February 3, 1983

RE: DRAINAGE PLAN FOR ALBUQUERQUE
NATIONAL BANK OPERATIONS CENTER
S01-224-18

In response to your letter of January 28, 1983, the numbered comments contained therein are answered as follows:

CATCH BASIN DETAILS

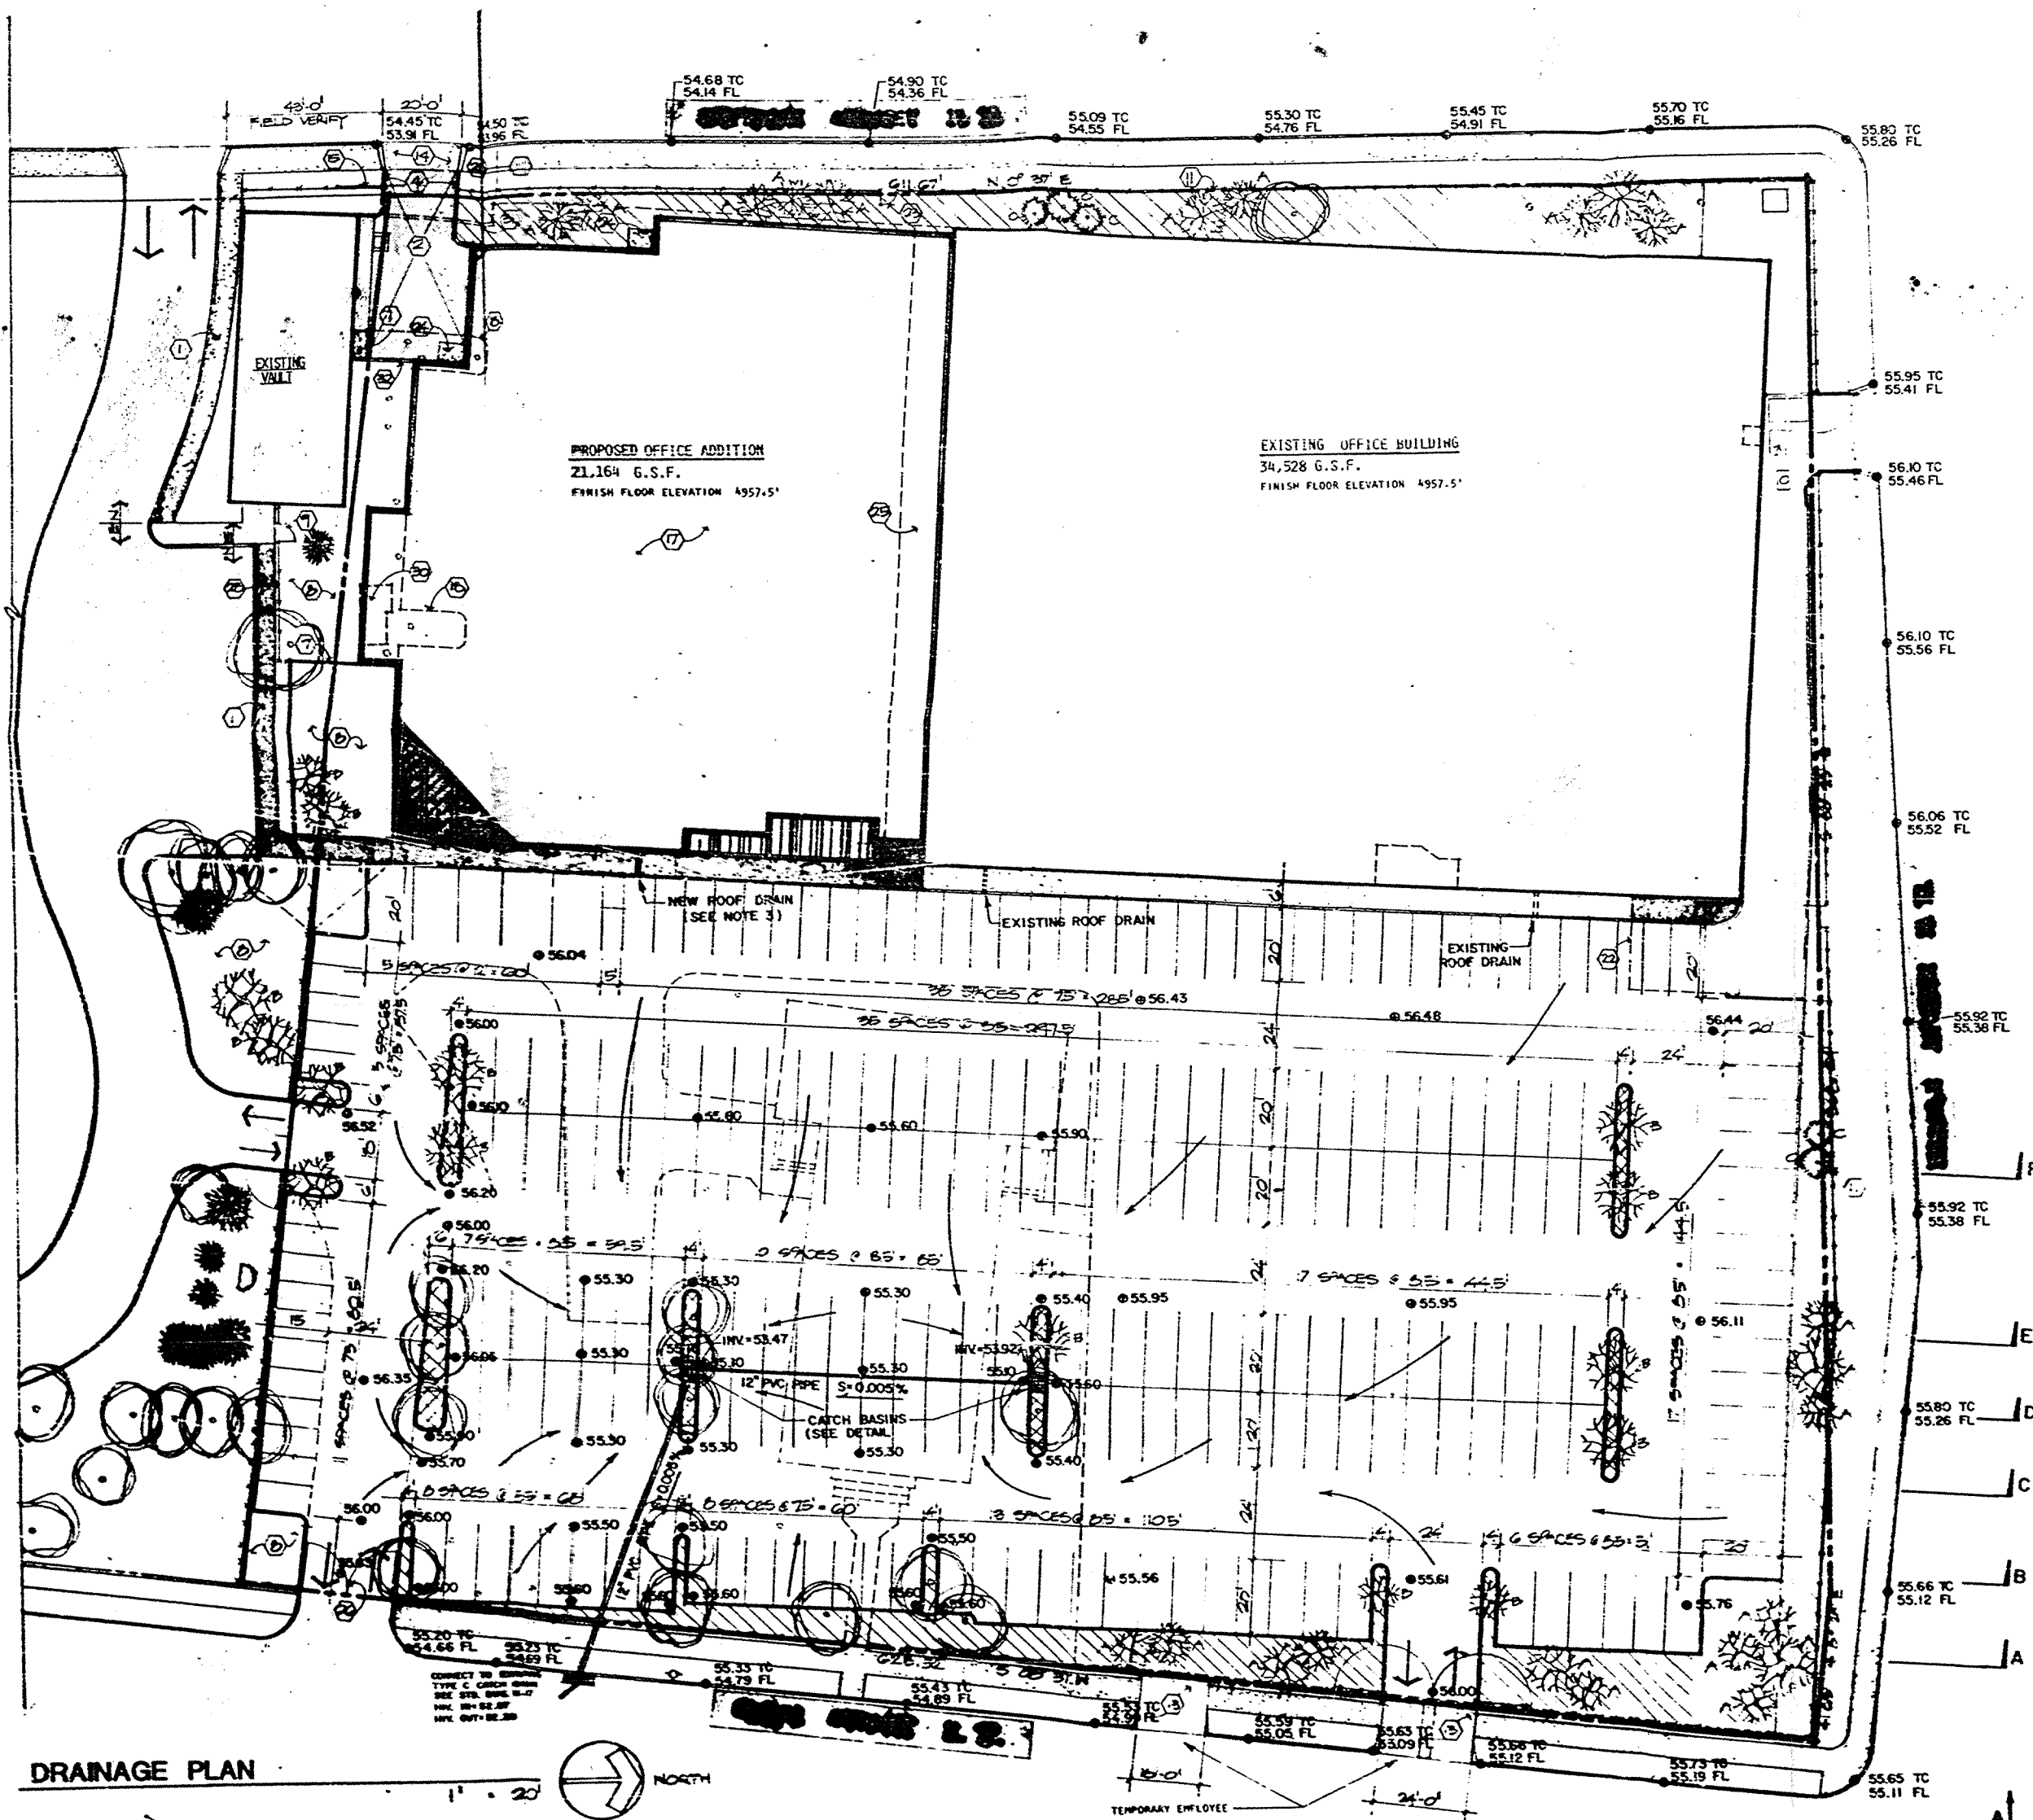
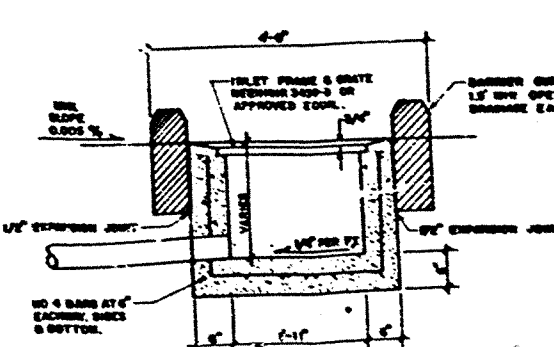
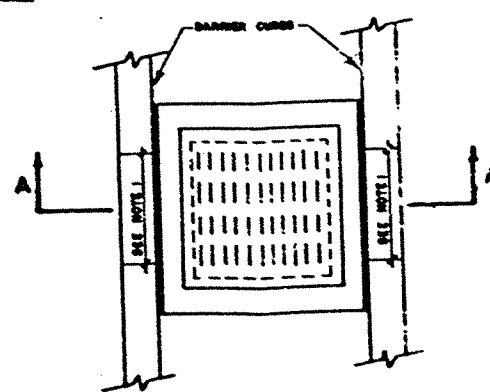
1. The 100-year ponding limit has been identified on the plan.
2. The orifice plate has been called out on Section AA of the catch basin detail. Also, it has been shown to apply only to the southern catch basin.
3. The finished floor elevation of the existing building has been referenced as a temporary bench mark. The south entrance was actually used as a T.B.M.
4. Approved copies of the Special Order No. 19 have been placed in the City construction sets. An approved copy is attached for your information.
